From: [Christopher Coote](#)
To: [Simon Truong](#)
Subject: Submission Details for company Strata Plan 19388 (org_object)
Date: Monday, 15 December 2014 2:05:13 PM

RE: MP08_0244 MOD 2 - Modification to Mixed Use Retail Residential redevelopment (Part3AMod)

2 WEST ELEVATION
SCALE 1 : 250

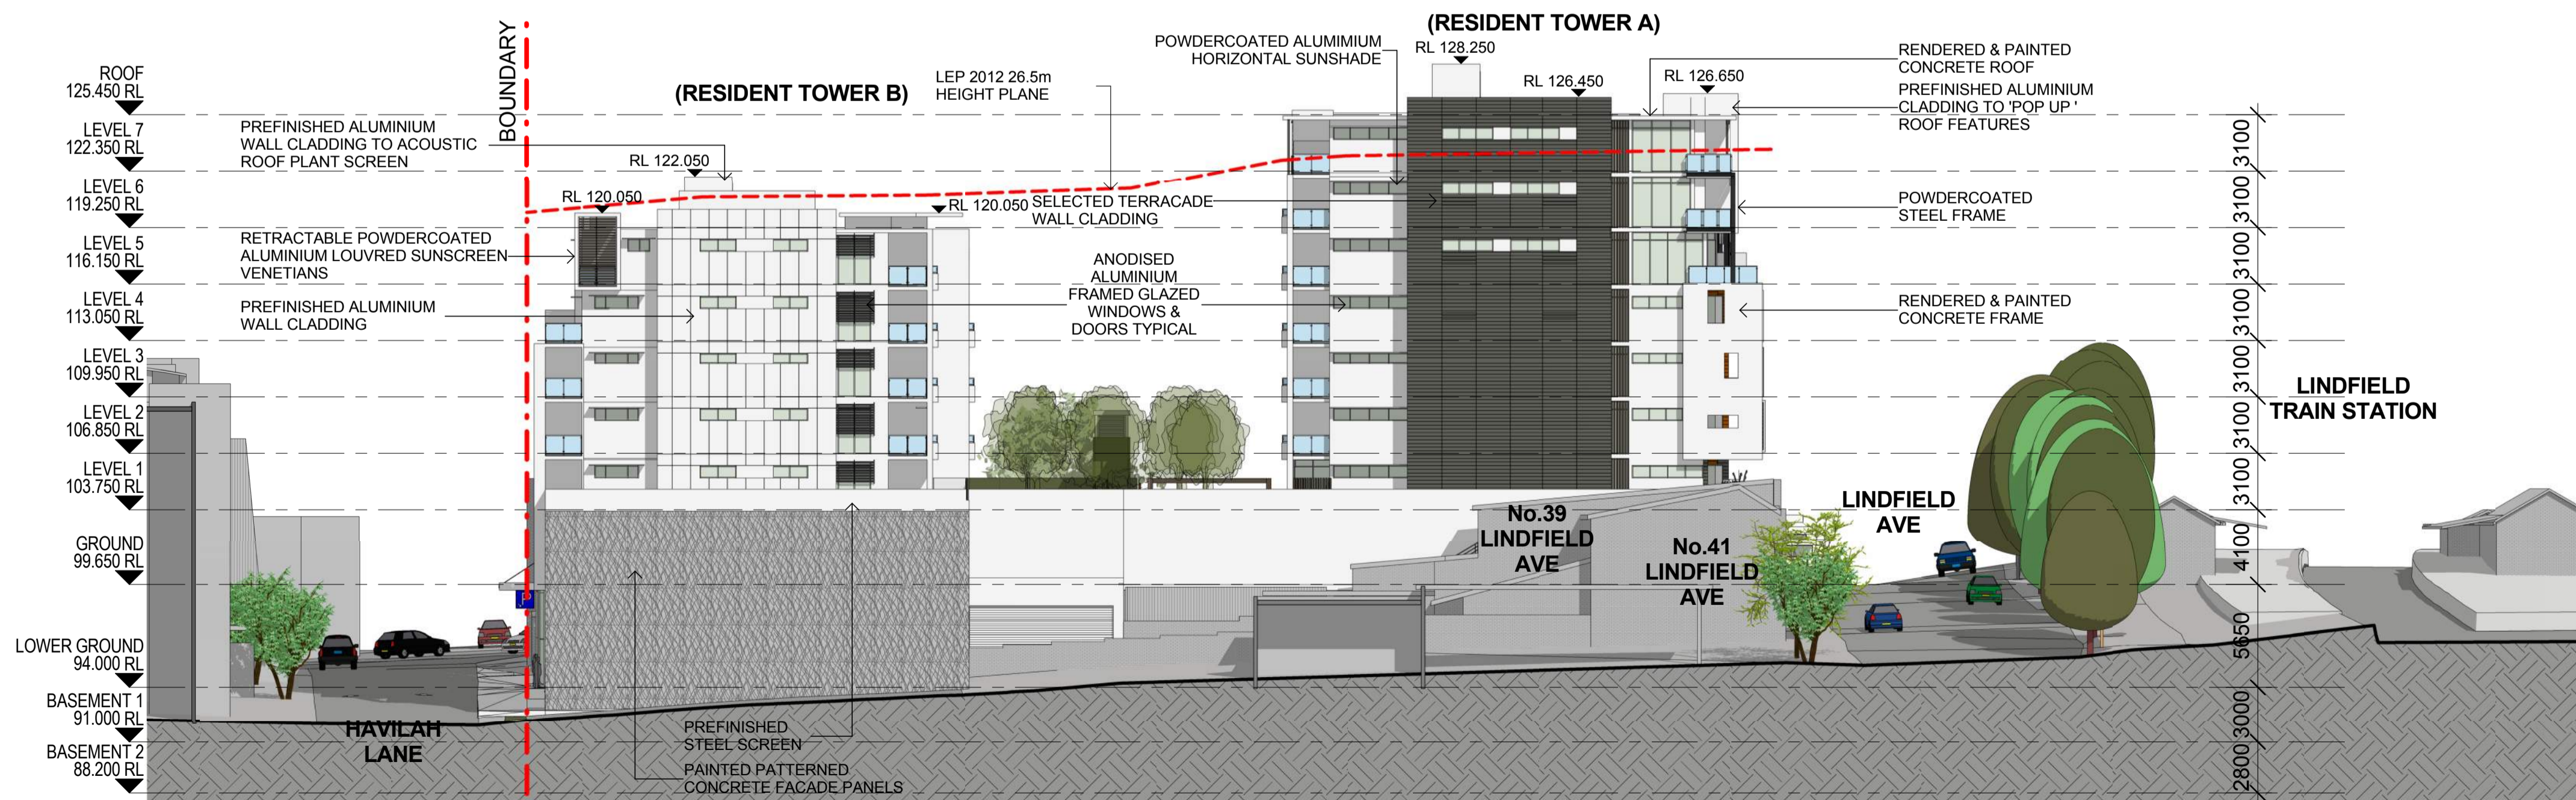
4. It is noted the building separation does not seem viable for our future development to the boundary in regards to the Western tower and its eastern facade (and our western facade). Can there be some covenant in regards to loss of solar access, privacy and views of this facade to ensure that our property is not compromised in height and glazing/balconies in the future on our western façade.

1 HAVILAH LA ELEVATION
 2001 SCALE 1 : 250

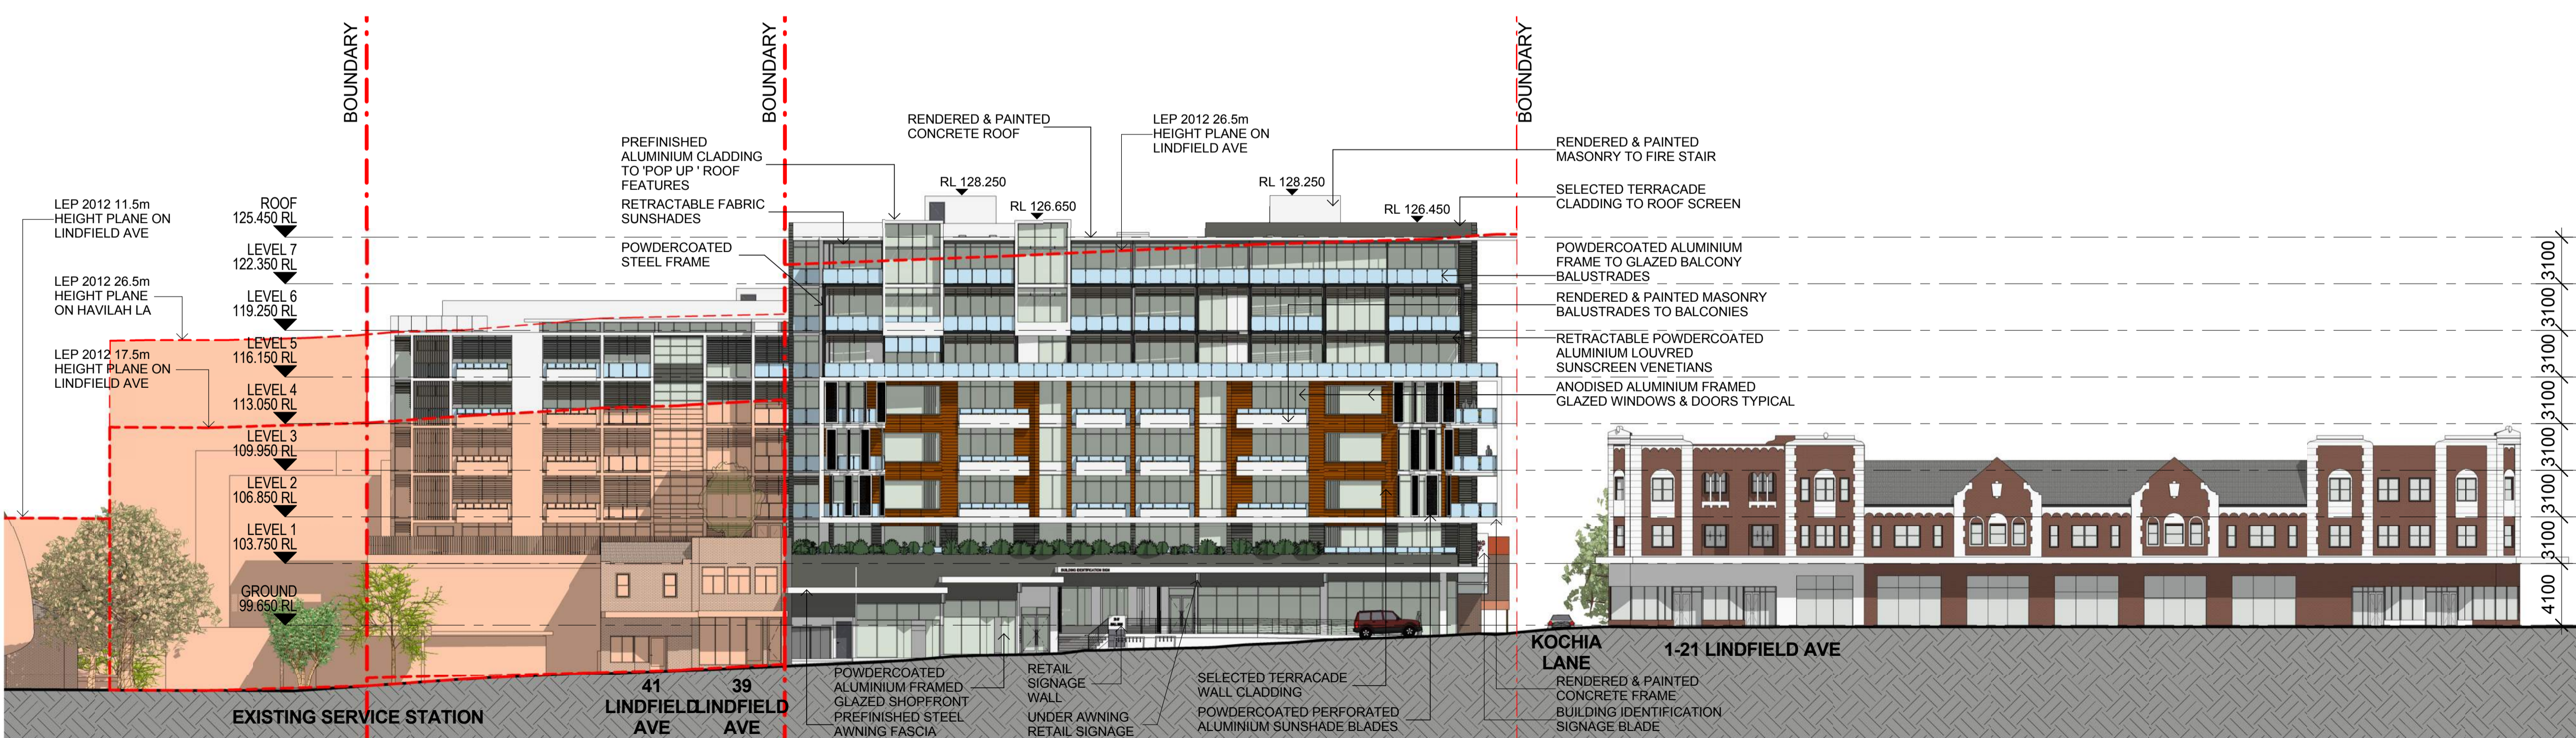
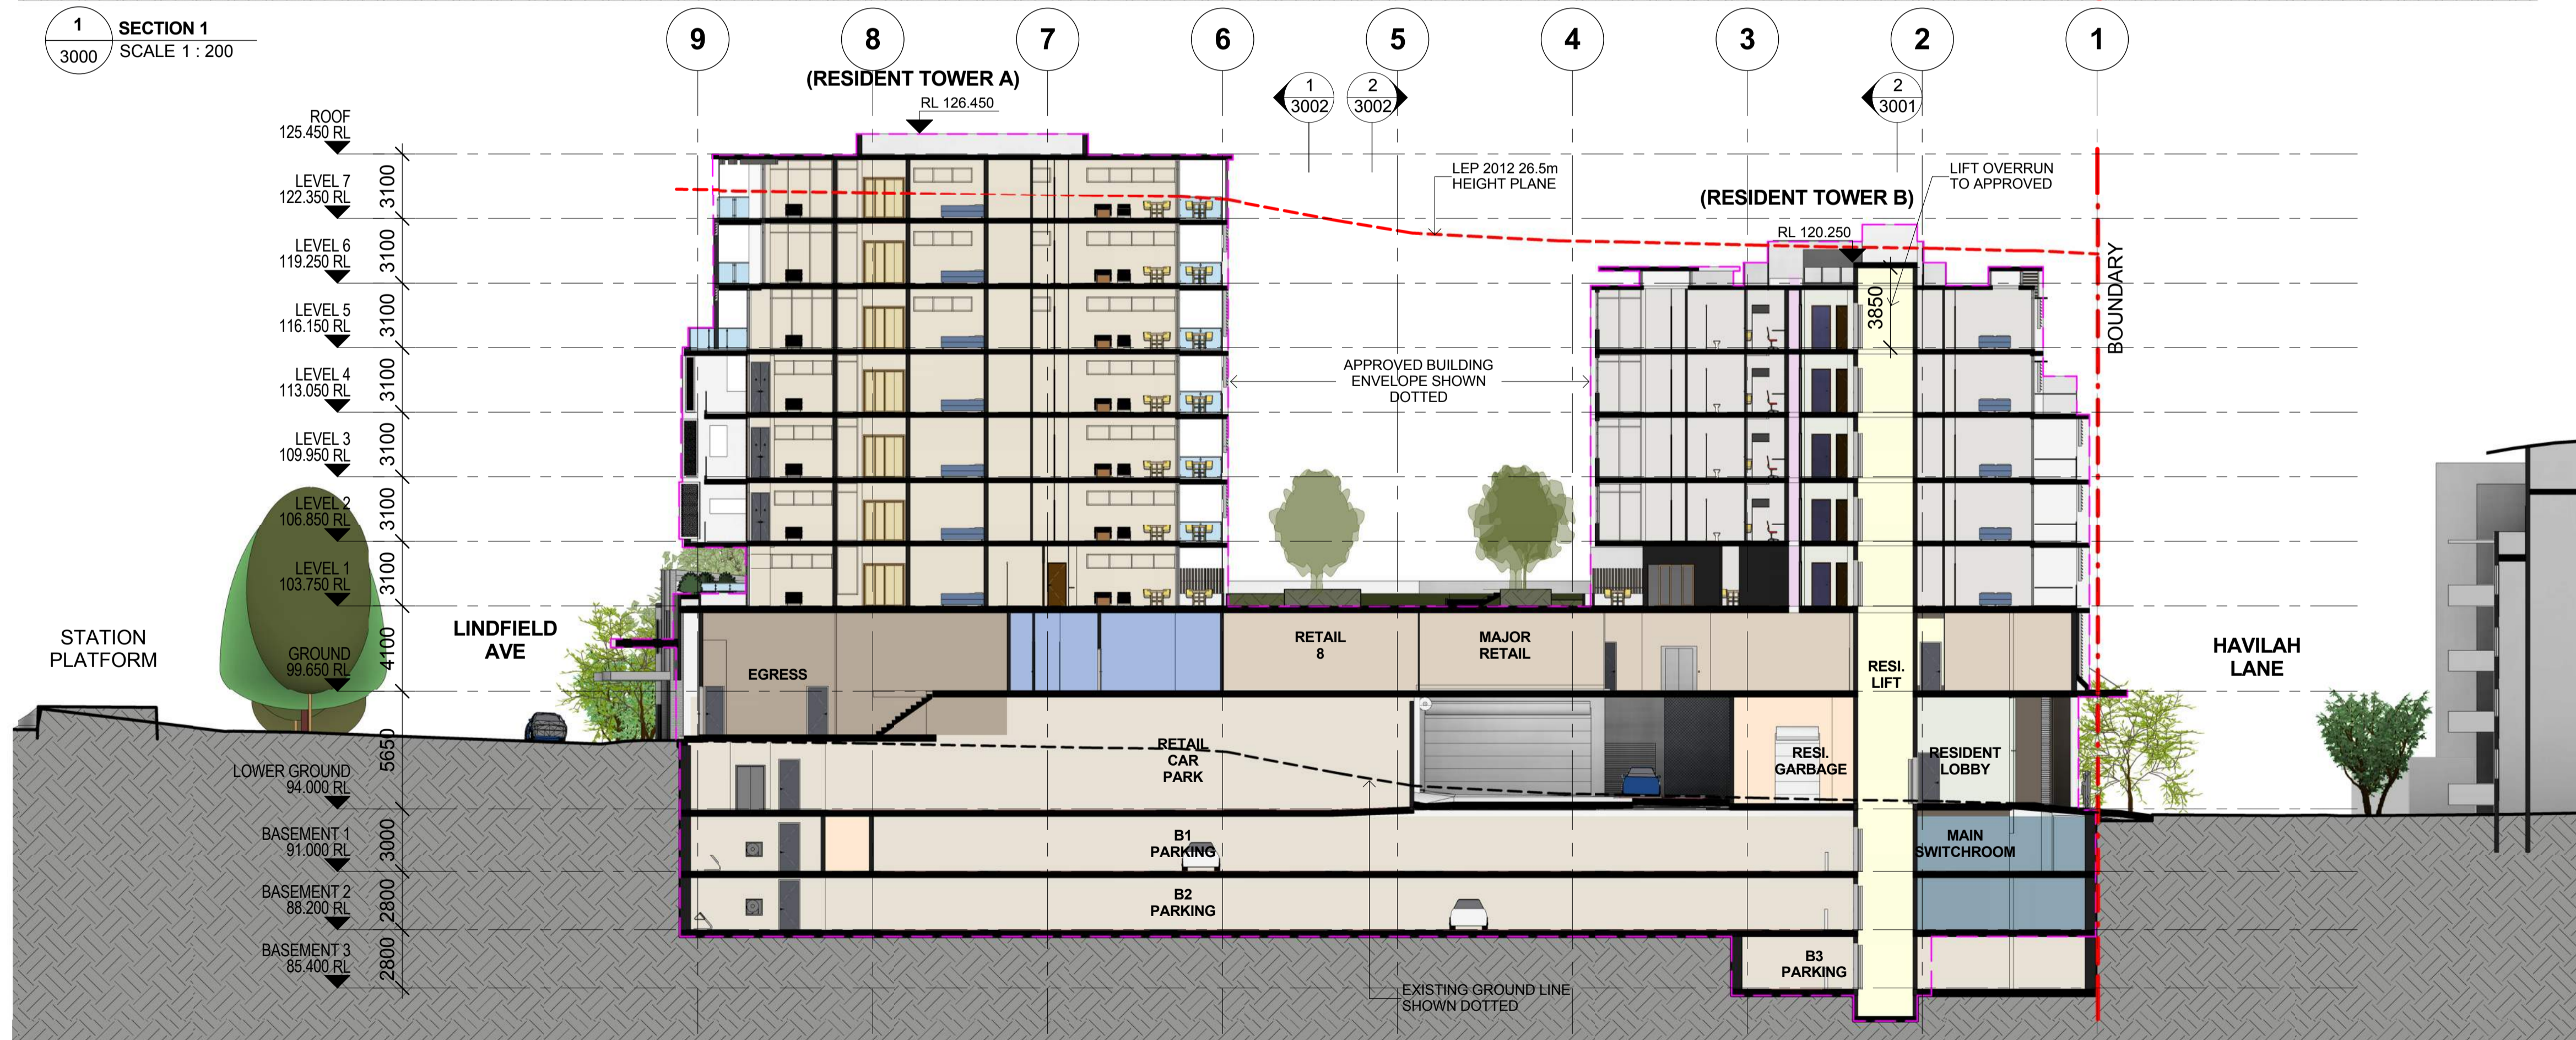
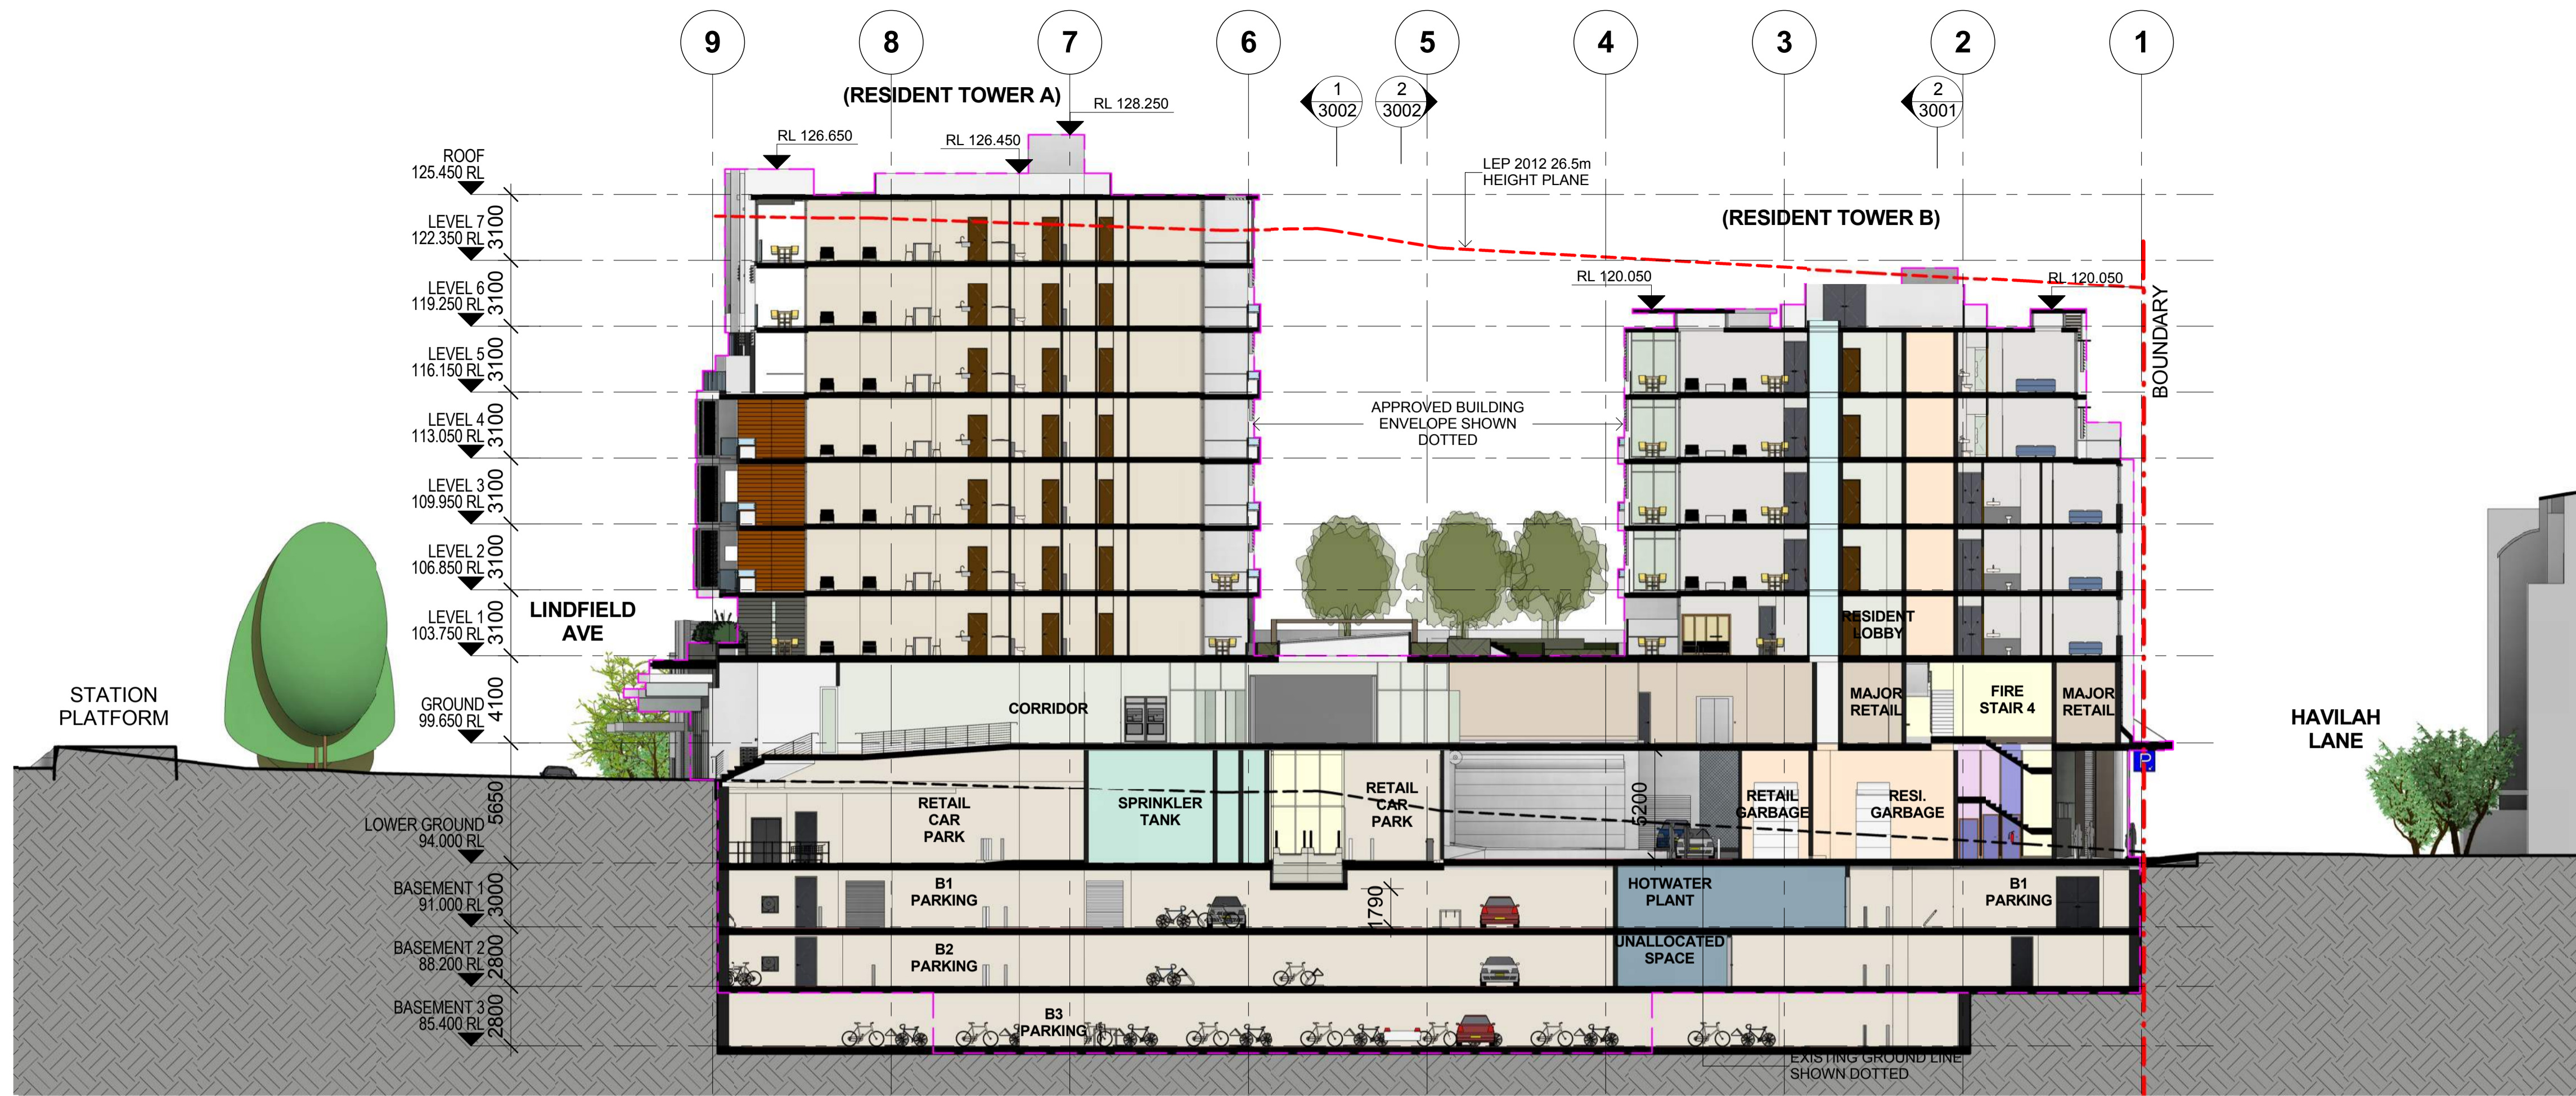
3. Please enforce your condition F17 - restrictive Covenant to solar access rights- to ALL glazing AND balconies on ALL levels of the southern facade of the Eastern Tower.
